From: Martyn White
Sent: 21 June 2019 11:45
To: Planning.Responses
Subject: AW/132/19/HH

AW/132/19/HH

The application relates to the provision of hardstanding to the front of a property located within the Craigweil House Conservation Area. The conservation area follows the boundary and layout of the estate as prepared by the architect, J. Auty. Most of the estate still bears the sense of being laid out as one unified piece, the street landscape and tree framework intending to create the rather "Arcadian" setting for house designs that would echo after the arts and craft and Tudoresque, and the 1930's aspirations - "a house in the country by the sea".

block plan

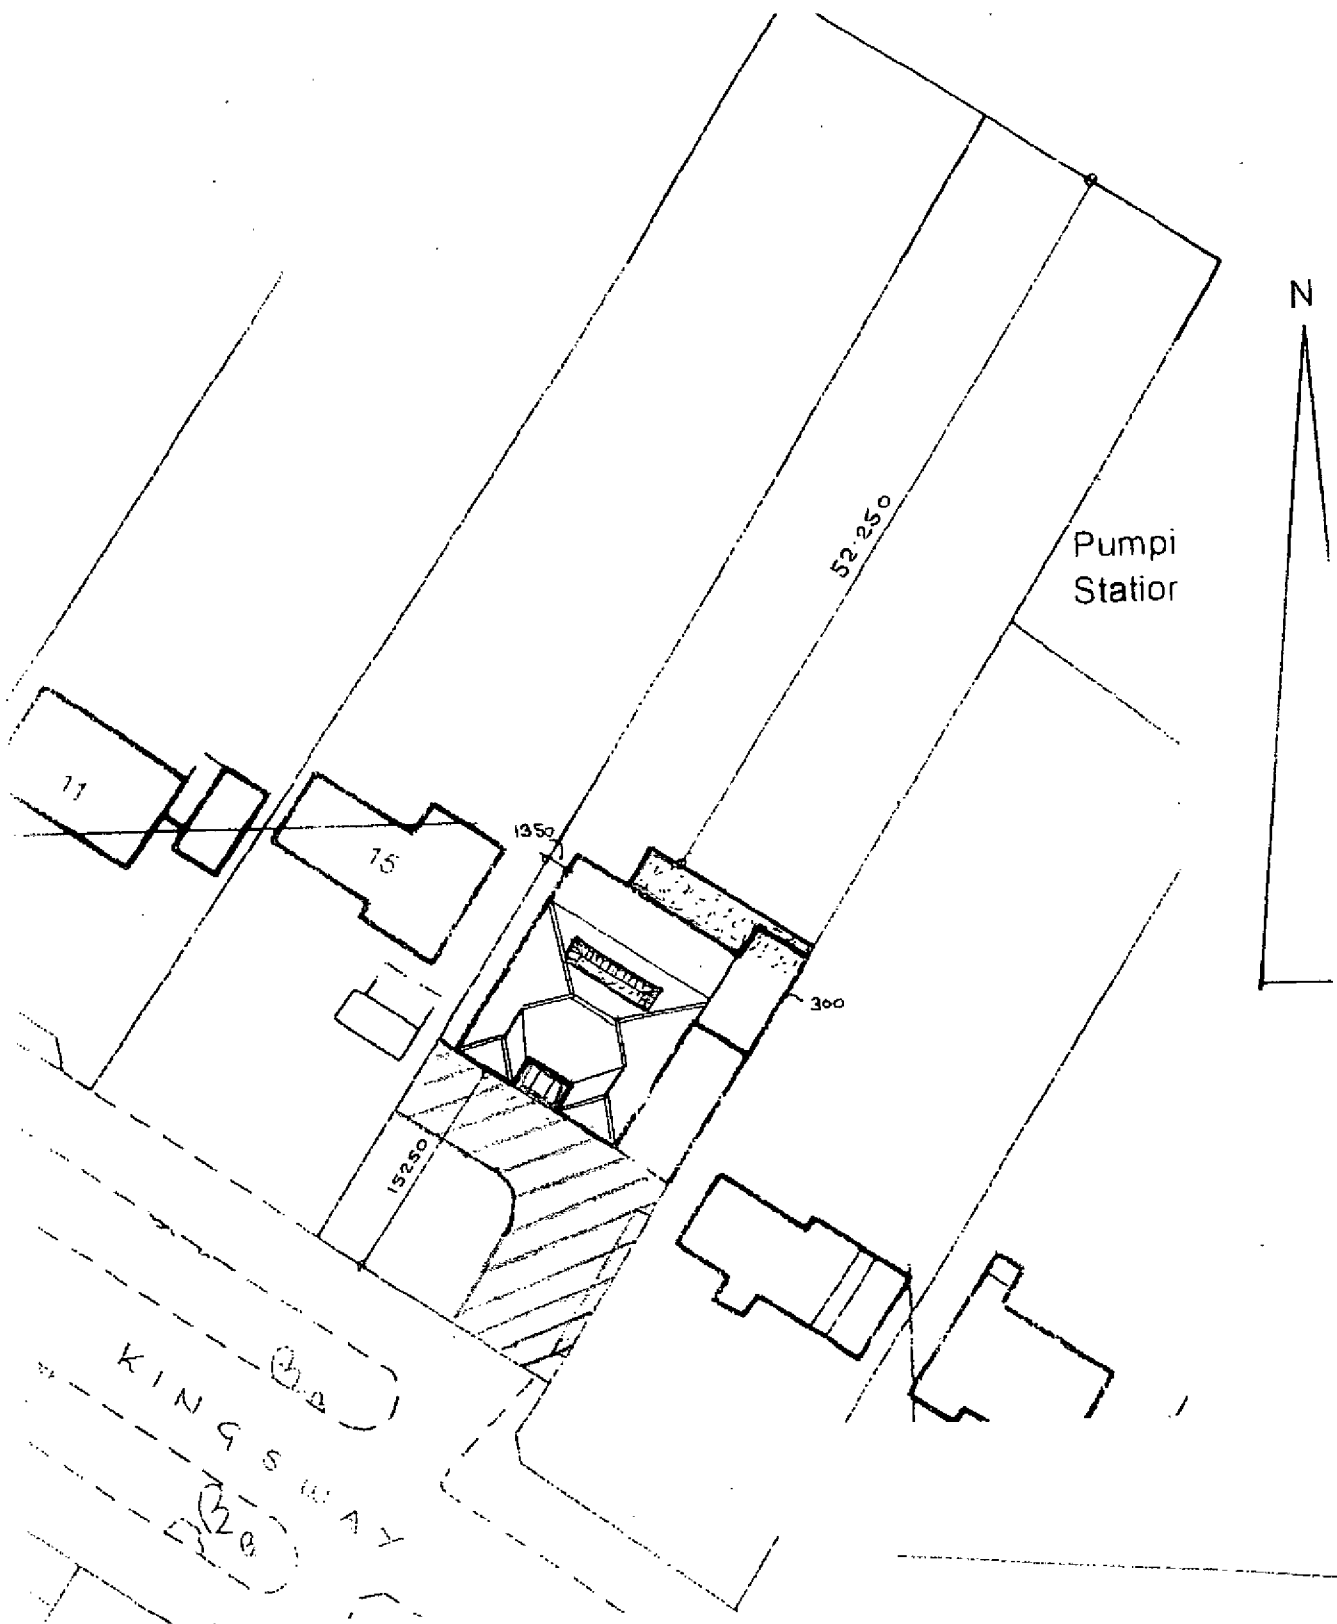
In this particular instance, the application is to replace an existing tarmac drive with one constructed from block pavements. It is thought that the area covered by the application will match that of the existing. The use of tarmac within the conservation area is harmful, and its loss will have a positive impact upon the character of the local area. It is considered the replacement pavements are more acceptable in comparison.

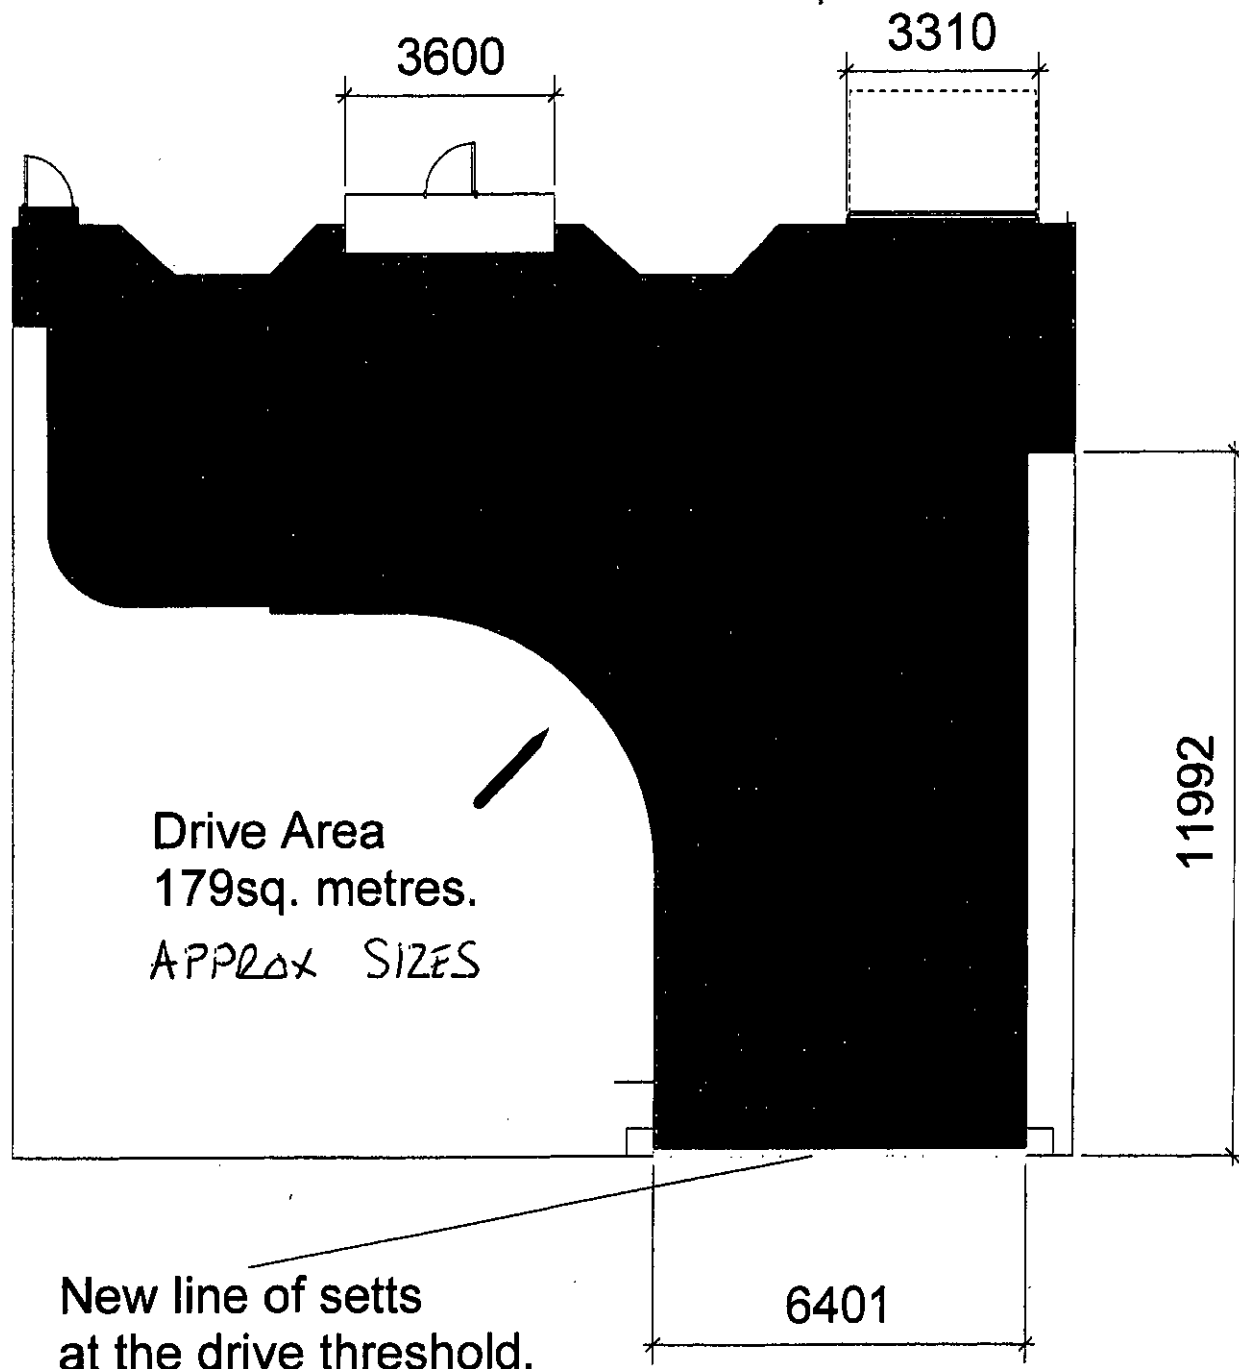
An indicative example of the pavements is provided as part of the application. The staggered bond indicated within the picture is acceptable and should be followed if the development is granted permission.

It is recommended that, if minded to approve the application, details of the paving should be submitted to the LPA and the bonding agreed.
